Preferred Project Response to Submissions Report

Section 75W Modification Major Project MP08_0244- MOD 1

23-37 Lindfield Avenue and 11 Havilah Lane

Mixed Use Development

1 KOCHIA LA ELEVATION
SCALE 1 : 250

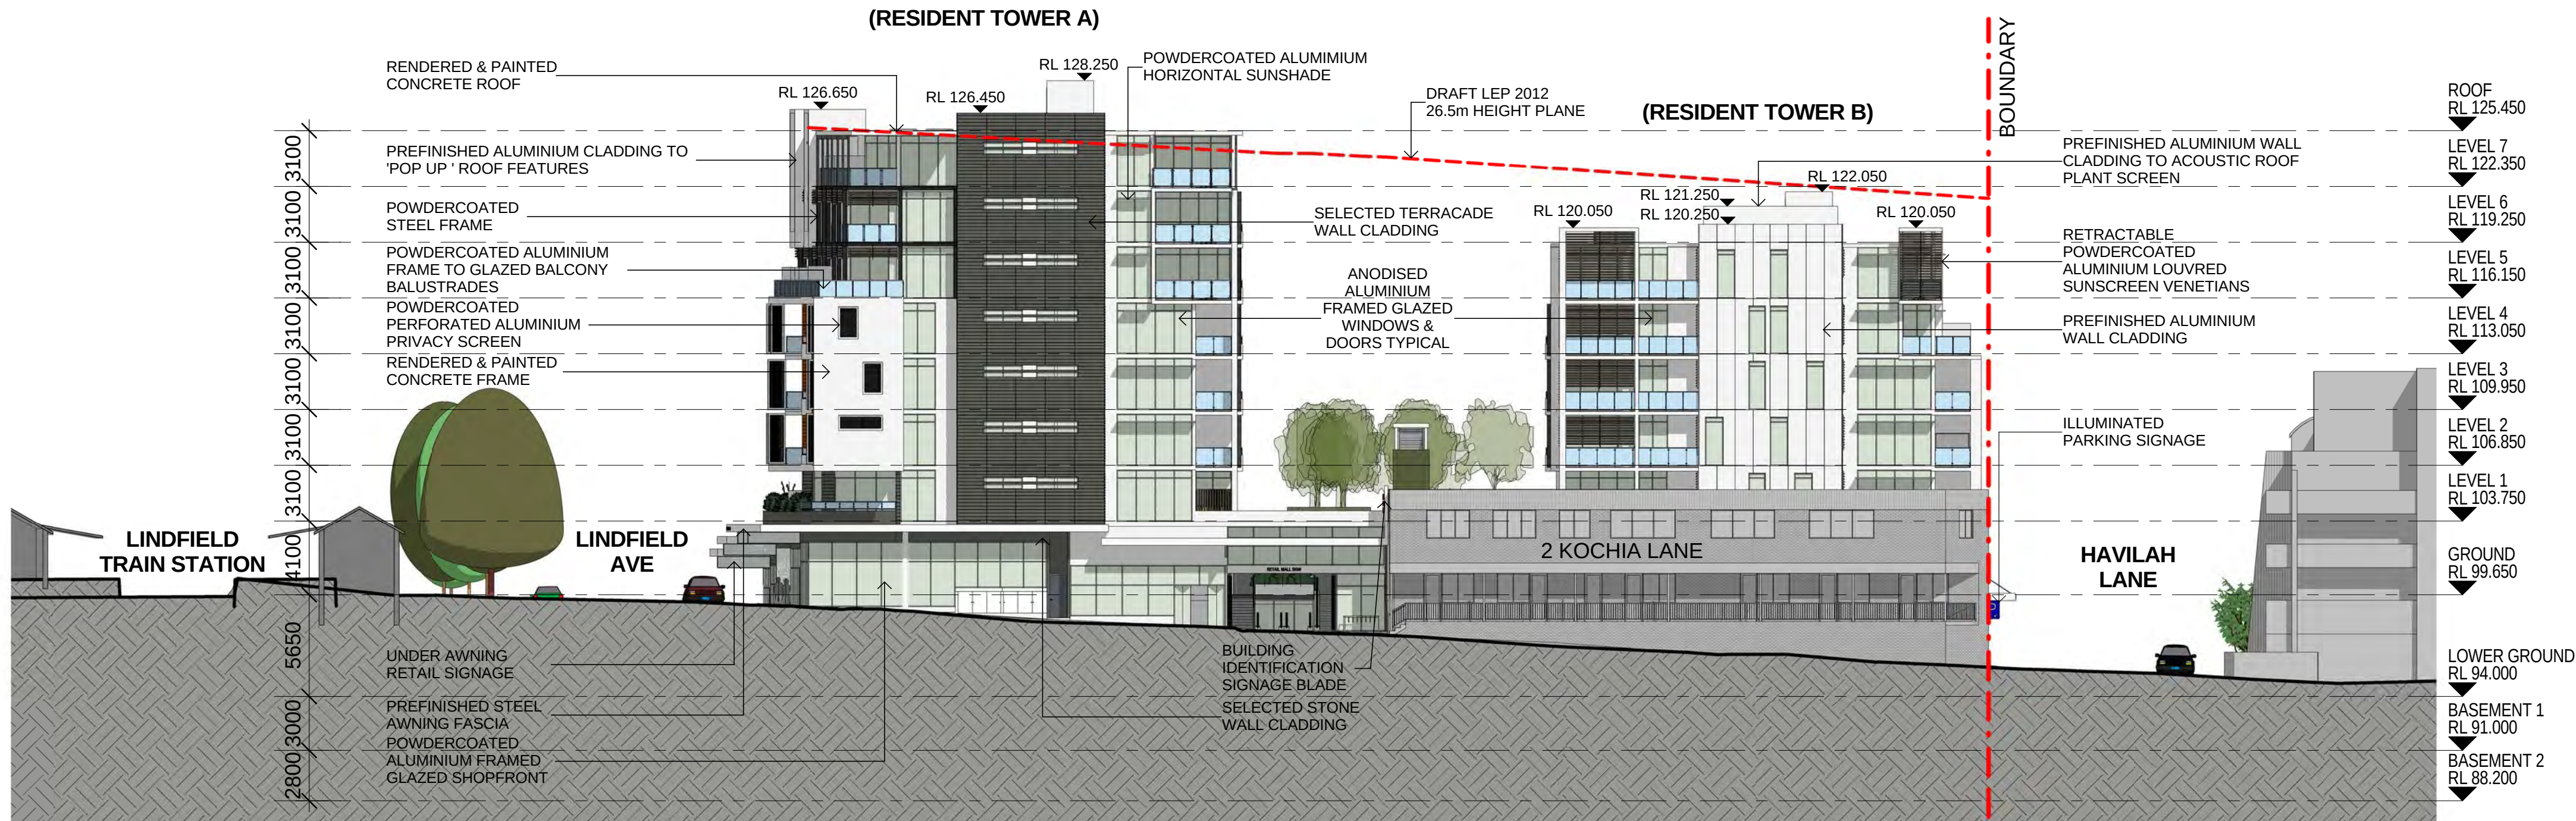
Further justification on the encroachments into the setback area of the upper levels of the building within the 4m setback to Kochia Lane and their impact on the future amenity and functionality of this space, having regard to Council's intentions for Kochia Lane, is required.

As noted in the submitted EAR, the Modified Project seeks to retain the 4m setback from Kochia Lane at ground floor level to enable the future widening works to be undertaken by Council at a later date. However, it is acknowledged that the proposed building will encroach the setback from Levels 2-5 with the 'floating frame' element that sets a unique and visual interest to the Lindfield Avenue streetscape.

ANKA considers this element of the building to be an important feature to the site and marks the area as a gateway into the Town Centre. The floating frame draws attention to Kochia Lane and will in turn attract pedestrian movement down Kochia Lane into the future Town Centre Council wishes to develop at a later stage. In addition, the frame adds articulation to the Kochia Lane façade and will be constructed of lightweight, highly transparent form with a white painted finish when viewed from the south and the east.

It should be noted that the ground level setback (which accommodates the 4m setback) will be dedicated to Council. This will still allow the future widening of the laneway which will provide the strategic intent for the inclusion of safe pedestrian footpaths to both sides of Kochia Lane and is consistent with pedestrian and traffic movement as per Council's Public Domain Plan. The balconies within the airspace can be privately owned through stratum ownership, which is commonly applied elsewhere, particularly within the Sydney's CBD.

As the proposed 'floating frame' element is a lightweight, highly transparent building structure and sets a strong visual statement for the building as well as providing a gateway to the future Lindfield Town Centre, it is considered that the element should be allowed to encroach within the 4m setback within the airspace. The setback is still achieved at ground floor level which will comfortably accommodate passing vehicles and pedestrians which is in accordance with the strategic objective of the Laneways' gateway into the future Town Centre.

2 LINDFIELD AVE ELEVATION
2001 SCALE1 : 250

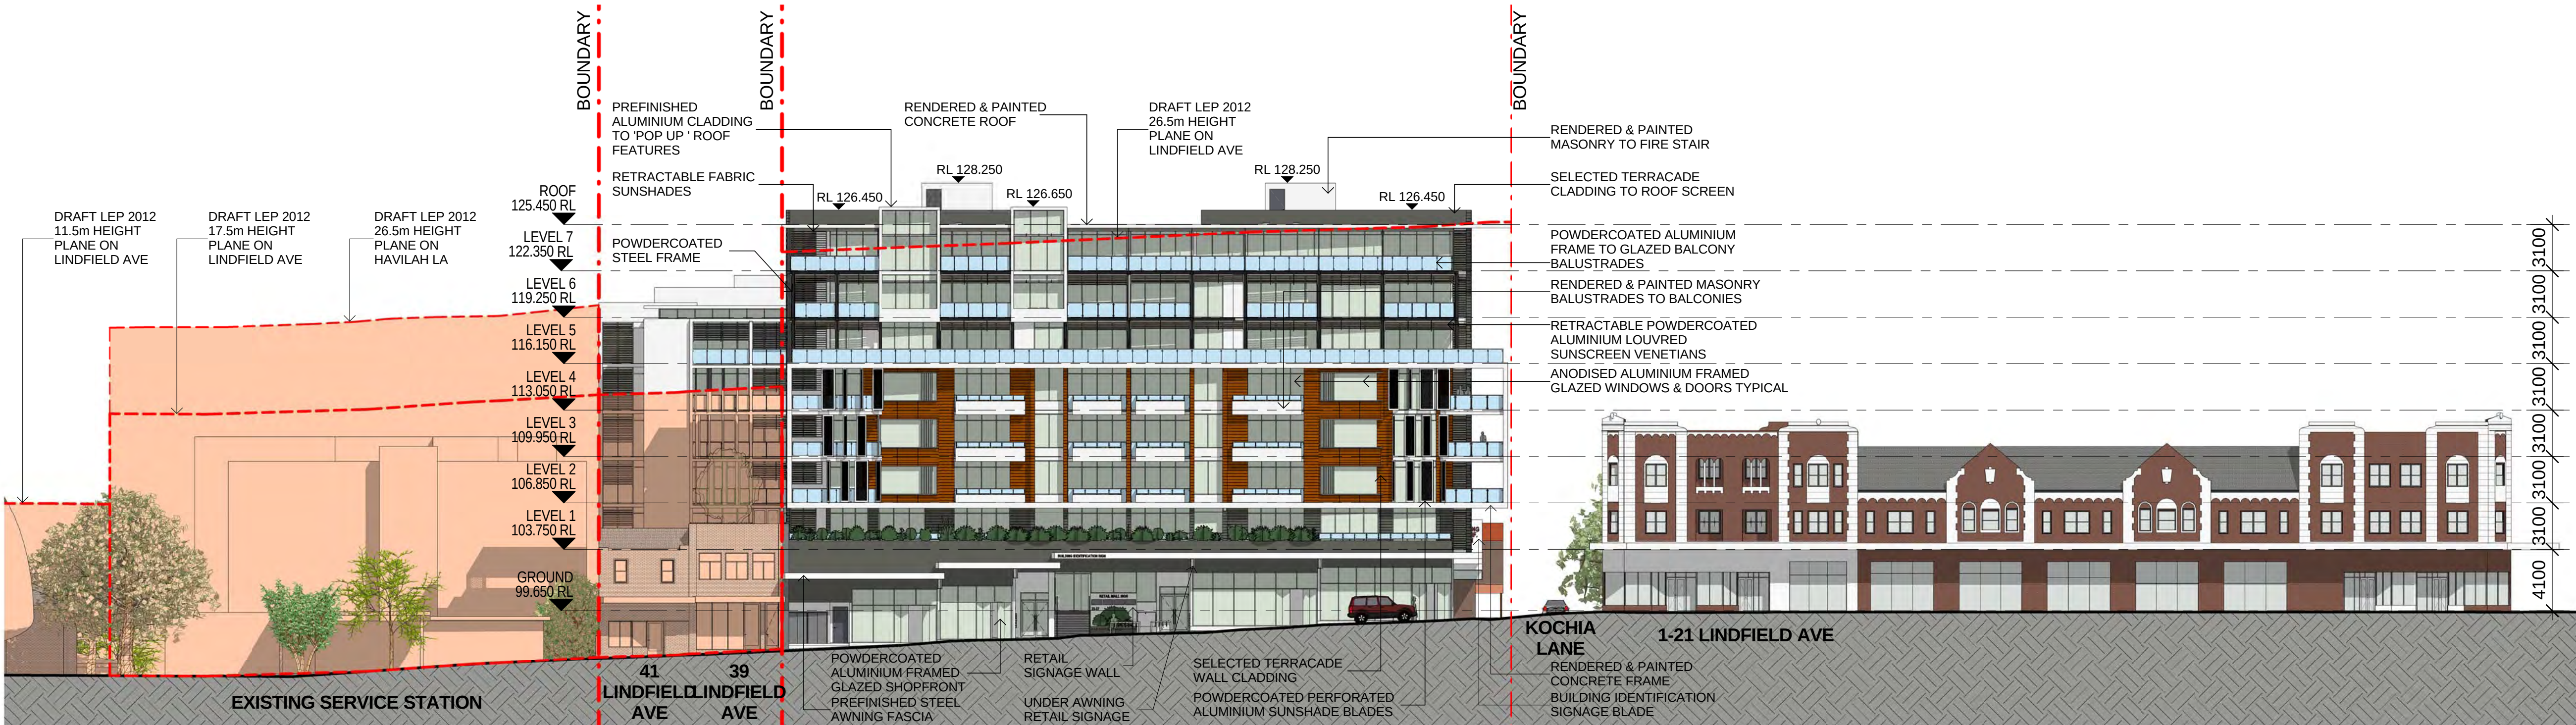
Justification for the departure from the setback requirements of the upper levels of the Lindfield Avenue frontage as originally approved – 2.0m between RL113.5 and RL119.5m AHD and 4.0m above RL119.5m AHD. The setback requirements were imposed to ensure the new building form related appropriately to the height lines of the adjacent heritage building at 1-21 Lindfield Avenue.

Crone Partners and Graham Brooks & Associates have provided responses (see **Appendices B** and **C** respectively) that provides robust urban design arguments for the departure to the approved setbacks.

The proposed building façade along Lindfield Avenue maintains an important relationship between the nearby heritage buildings located on the other side of Kochia Lane and the new building provides a composition that has been articulated to form a distinct hierarchy of base, podium and top levels. This creates a clear transition of low-rise, linear streetscape that steps up to a new town centre form and architecture.

Grahams Brooks & Associates (**Appendix C**) notes that the imposition of the original setbacks requiring the massing of the new building to be closely aligned with the streetscape scale of the adjoining heritage building is a misguided perception. The setback requirement considered false by Graham Brooks & Associates in this circumstance as the proposed building is not set up hard against the existing heritage urban setting and is separated by Kochia Lane. The proposed building should therefore retain its unique architectural quality and integrity which also plays an important factor for the relationship to the heritage building.

The imposition of the original setbacks will weaken the composition of the building and surrounding buildings and will in the opinion of Graham Brooks Associates degrade the integrity and success of the new building by devaluing the success of the current façade and the massing composition. In addition, Crone Partners (**Appendix B**) notes that a stronger podium form and articulation with distinct 'solid' façade elements will define a more dynamic Lindfield Avenue streetscape, rather than producing multiple levels and setbacks that would result in a weaker layered appearance.
